## RE: Cranbrook School Redevelopment (SSD 17\_8812) – Response to Council Comments

This letter has been prepared to provide responses in relation to Council Comments (dated 2nd October 2018), as listed below:

Figure 1 - Location of Bicycle Parking

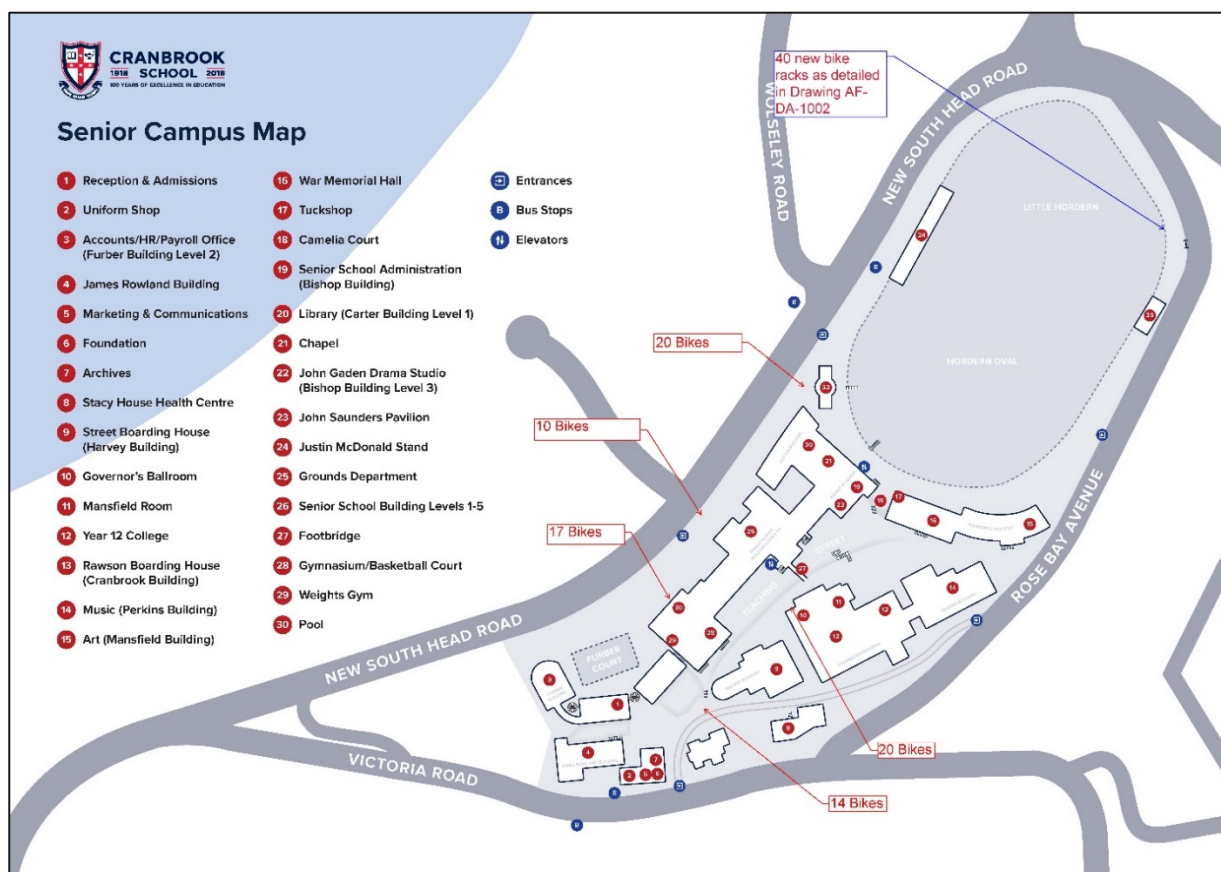
- Adequate on-site provision shall be made for bicycle storage and facilities in accordance with Part E1.6 of Woollahra DCP 2015 (Condition 3)

The proposed Basement 1 car park includes the provision of 20 bicycle spaces and 20 spaces within the forecourt of the Aquatic Centre, therefore requiring a further 78 spaces throughout the rest of the campus.

There are currently five locations within the campus where bicycles are stored/parked and as part of the development, 78 spaces will be formalised with bike racks to provide the required bicycle provision.

Given that there is no proposed increase in staff or student numbers as part of the development, the provision of 40 additional spaces and the formalisation of the existing provisions, are deemed acceptable, in accordance with the DCP requirements and also promotes a healthier and an alternative mode of transport for both staff and students.
